Our ref: DOC21/830972

Senders ref: SSD-9874-MOD-1

6 October 2021

Subject: Walla Walla Solar Farm – Panel height increase (SSD-9874-MOD-1)

Figure 5-3 Walla Walla Solar Farm proposed modified access point for all traffic during substation construction

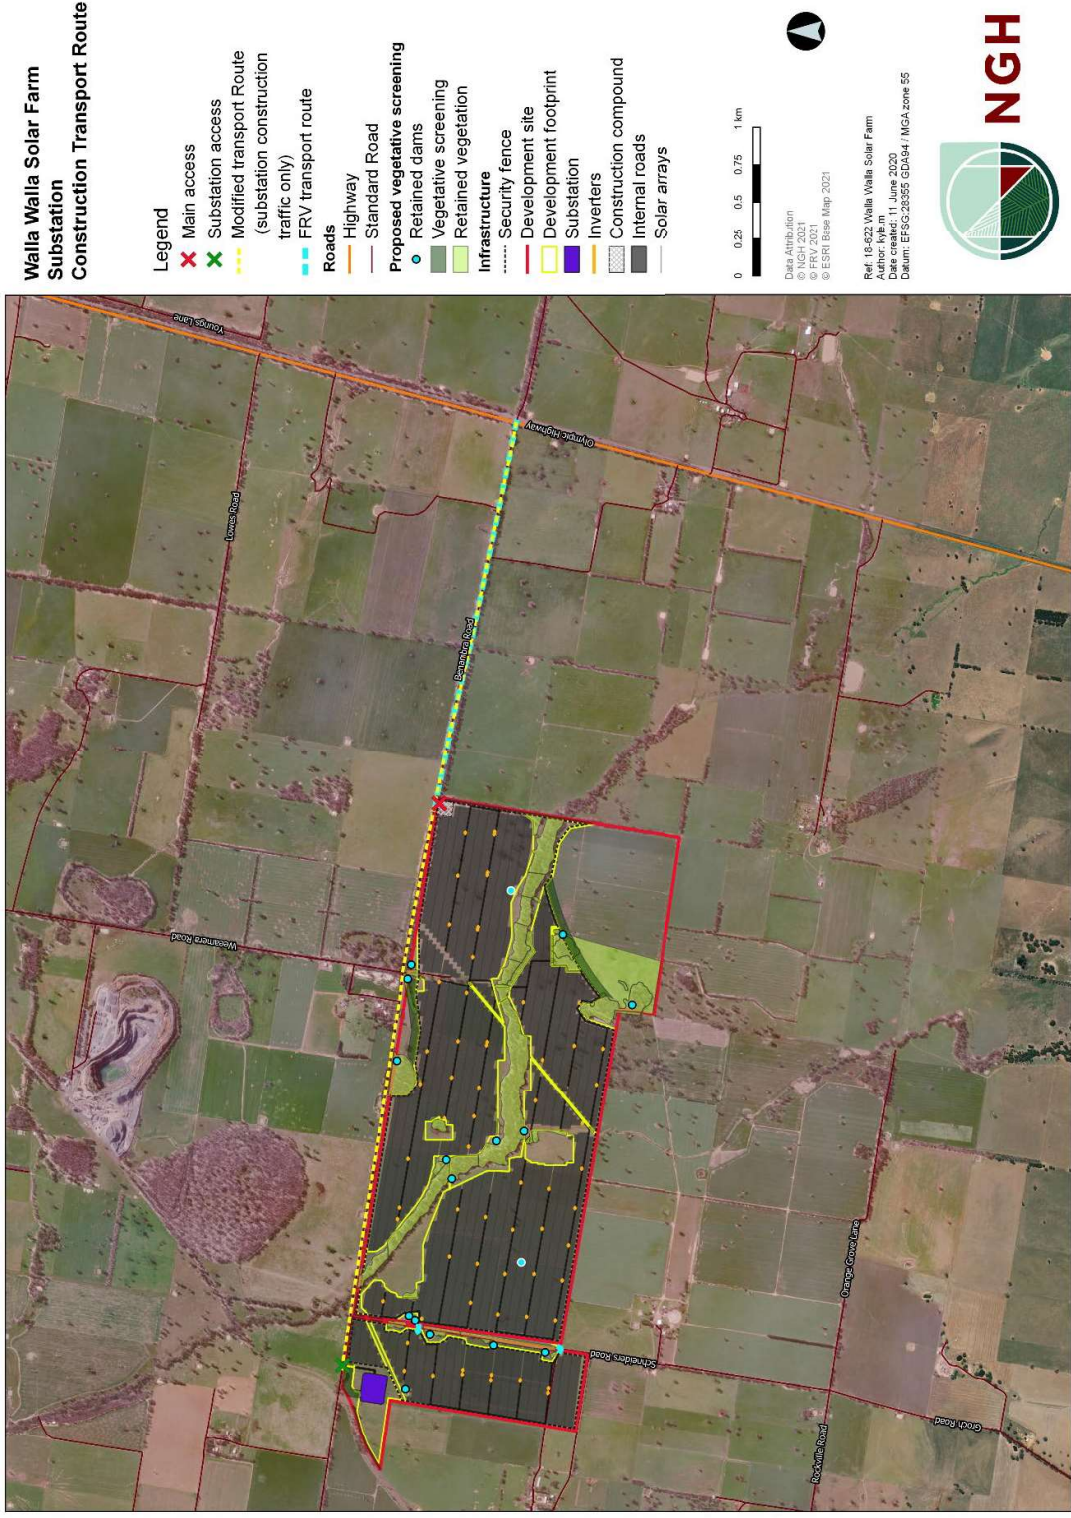
- clearing of vegetation for widening the sub-station 'alternate access' intersection
- possible upgrades required for heavy vehicle use of the unsealed section of Benambra Road to the west of the approved main access. Upgrades to Benambra Road were not assessed in the original Environmental Impact Statement (EIS). Upgrade activities could include trimming of trees for the required vehicle height/width, clearing of vegetation for drainage construction and storage of road construction material.
- it is unclear if additional vegetation clearing is required for oversize vehicles to turn into the sub-station site from Benambra Road via the alternate access.

The Modification 1 Application states in Section 4.2 (page 12) that the proponent considers road upgrades to be unnecessary and proposes to maintain the road during construction in accordance with the development consent. It also states that over-dimensional vehicle access to the substation site is already permitted by the project consent.

The Modification 1 Application does not provide any discussion about the vegetation at the alternate access location from Benambra Road. Aerial imagery shows that there are no trees in the general location, however native vegetation, threatened species habitat and threatened ecological communities can exist in areas without trees.

If the vegetation is considered not to be native, we would expect to see evidence that plant species richness and cover of the roadside vegetation was surveyed.

We recommend the proponent provide evidence that the any vegetation to be impacted has been surveyed according to the Biodiversity Assessment Method (BAM), and is either not native, or matches one of the vegetation zones assessed for the BDAR. Any impact to native vegetation or threatened species habitat should be assessed according to the BAM.
